# **SECTION 4.55(1A) MODIFICATION REPORT**

**S4.55(1A) APPLICATION TO MODIFY  
DEVELOPMENT CONSENT SSD-66826207**

**405 Pacific Highway, 5 Falcon Street &  
8 Alexander Street, Crows Nest**

**May 2025**

Figure 2 Swept paths around central column

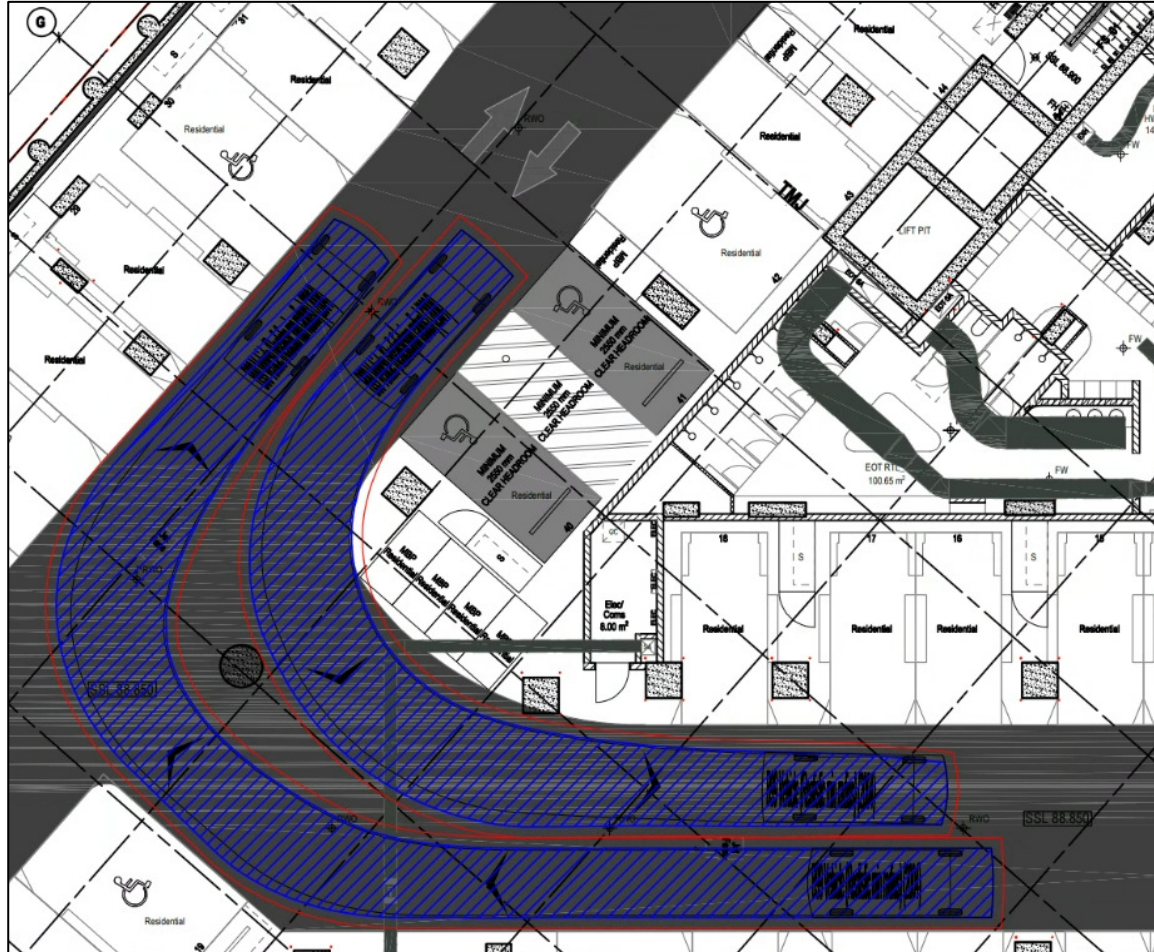
<p>A pillar has been introduced in the middle of the aisle (red circle below).</p> <ul style="list-style-type: none"> <li>• Consider deletion of this pillar for all</li> </ul>	<p>The accompanying Transport Assessment prepared by JMT Consulting (Appendix 5) confirms that the basement design</p>

levels or provide swept path templates demonstrating adequate vehicle manoeuvrability.

- There are concerns the pillar will create a blindspot to the surrounding car spaces.

maintains appropriate space for vehicle manoeuvring and passing. Swept paths around the central column indicate that a 'B99' vehicle can appropriately manoeuvre either side of the column. Refer extract of Figure 2 from the Transport Assessment below.

As part of the subsequent detailed design process, signage and line-marking will be introduced to manage vehicle movements around this column. 'Keep Left' signage would be installed on the column and pavement arrows marked to ensure drivers safely navigate this area.

Appendix A: Vehicle Swept Path Analysis

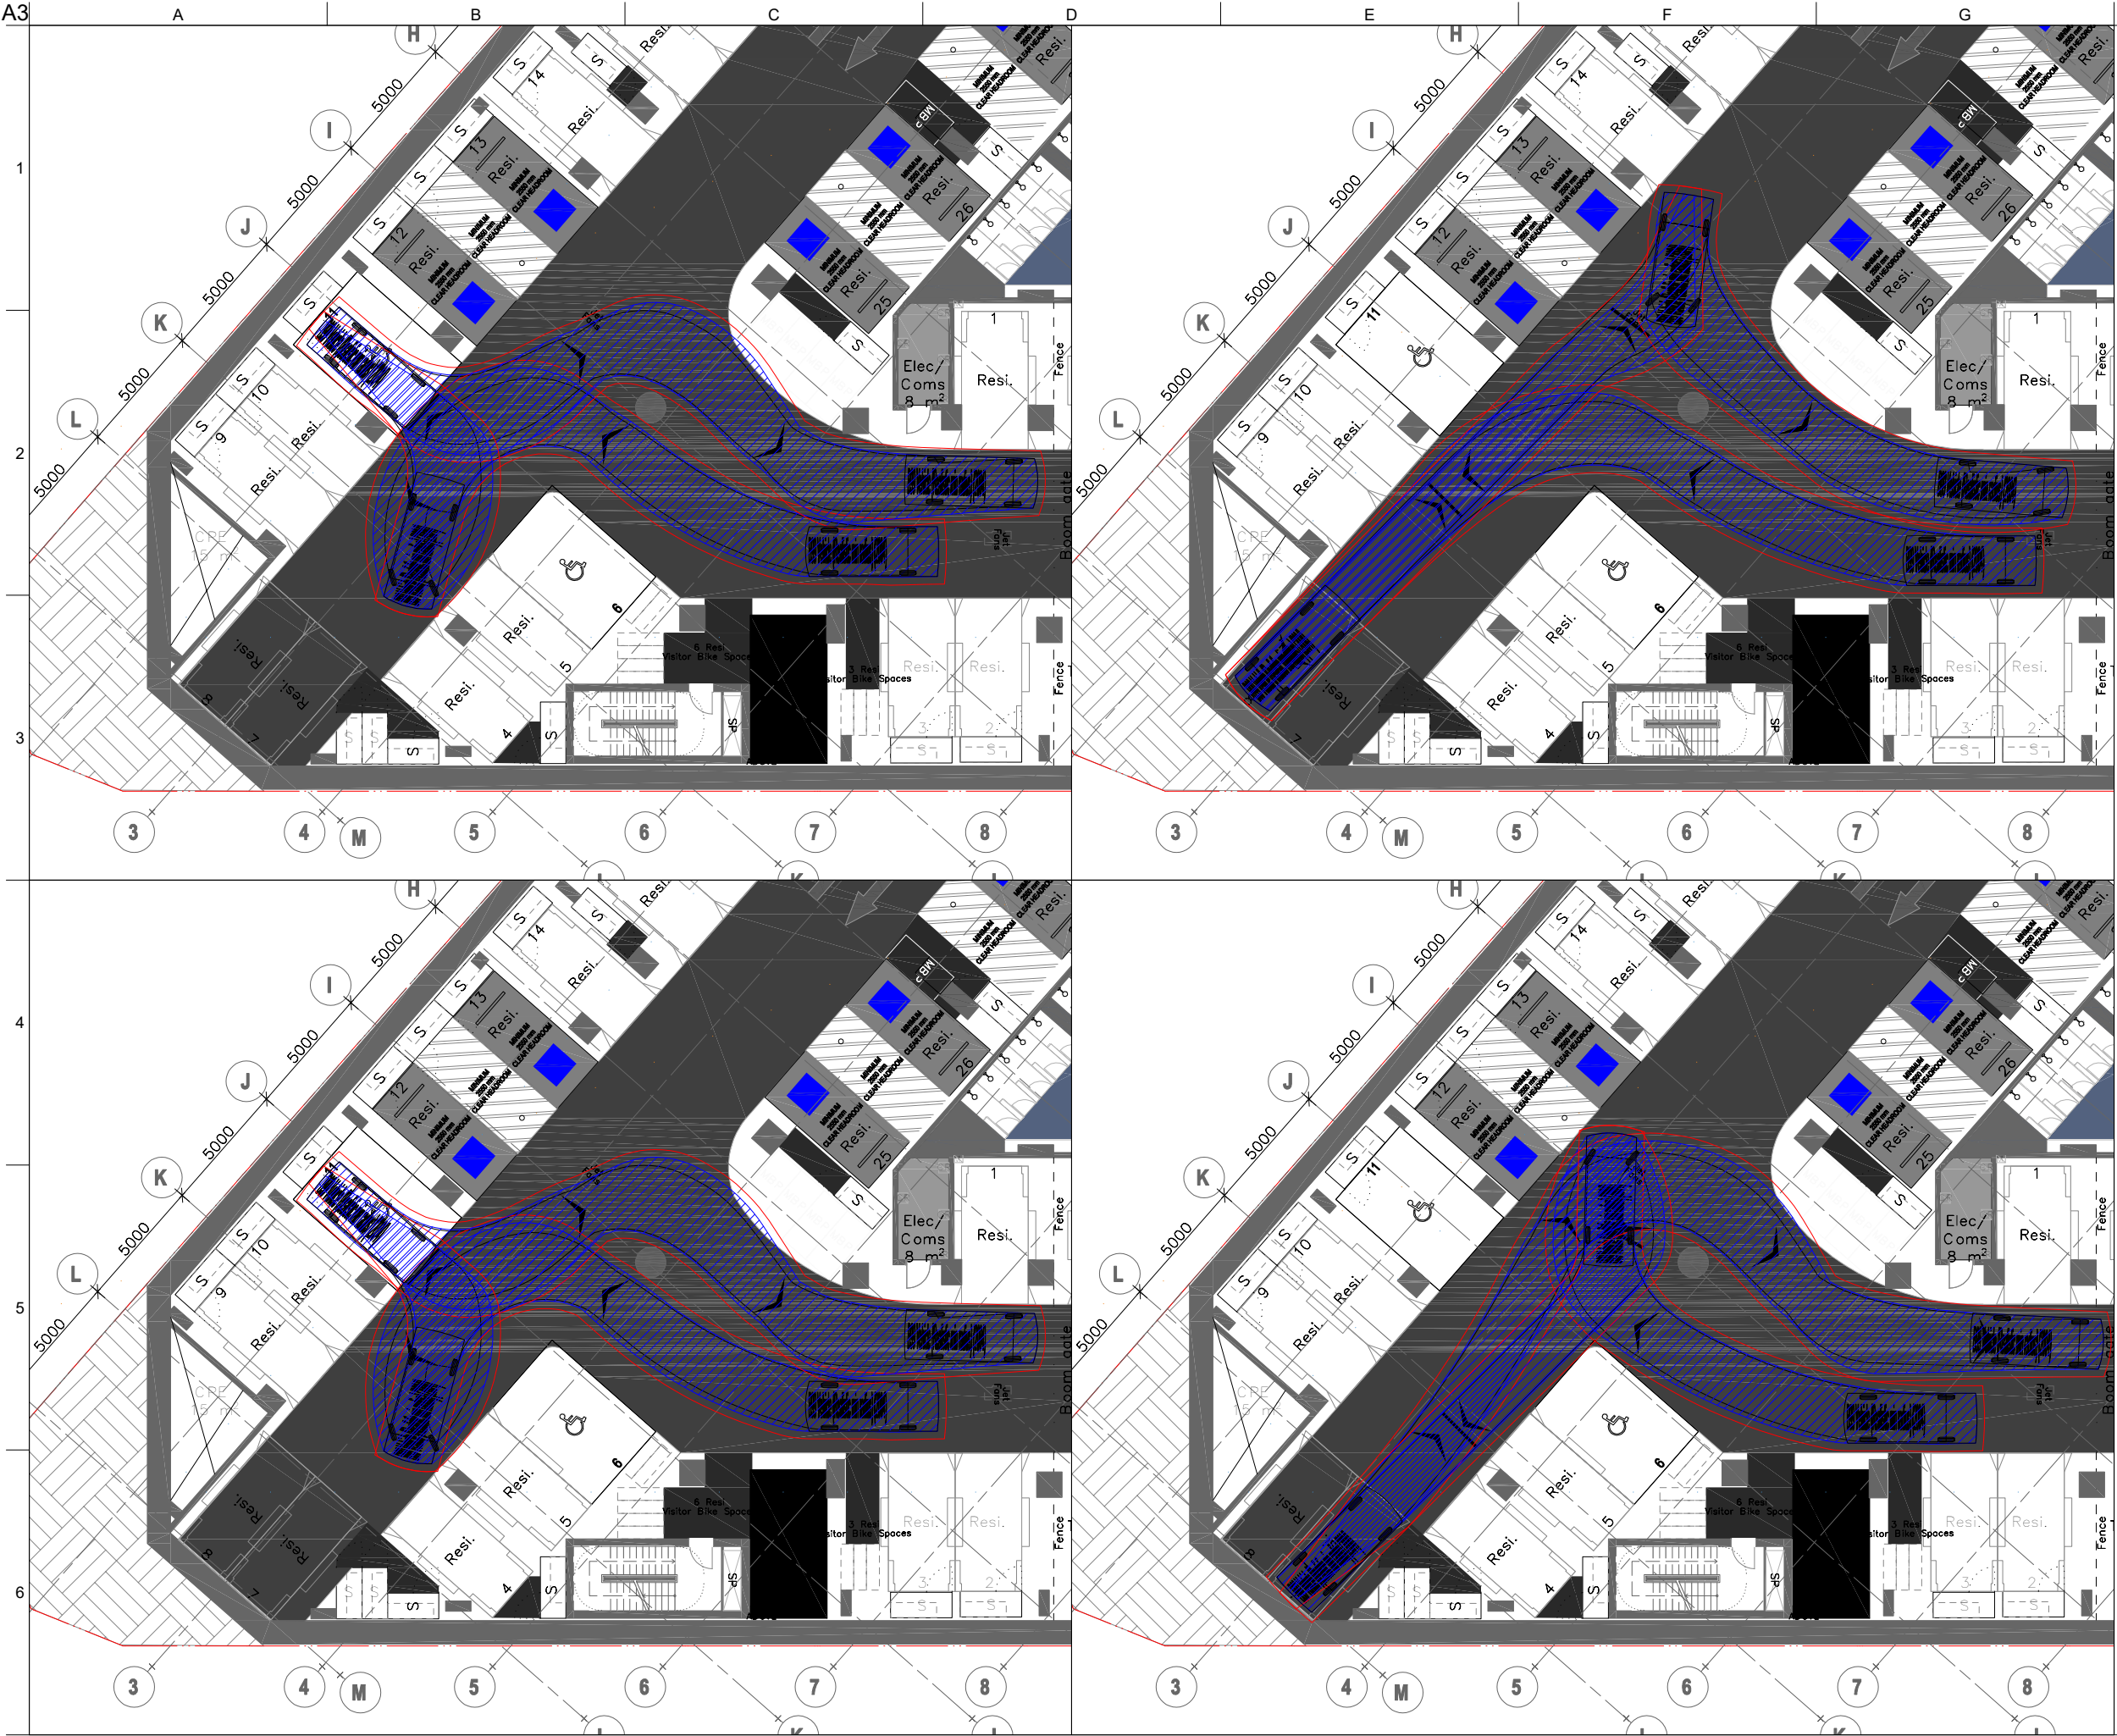
Please note that during assessment of the modification application, concerns may be likely raised on the tight layout of the car parking spaces (i.e. car parking spaces 161-166 and 158-160 above). It is suggested that you provide evidence and statement from your traffic consultant confirming that all car parking spaces proposed (to all 5 basement levels) will have adequate vehicle manoeuvrability.

As discussed in the accompanying Transport Assessment, detailed swept path analysis confirming that all car parking spaces can be accessed on all basement levels has been undertaken. This confirms the car park has been designed appropriately to relevant standards and will have adequate vehicle manoeuvrability. This swept path analysis (undertaken by Turner Traffic on behalf of Deicorp) is provided at Appendix A of the Transport Assessment.
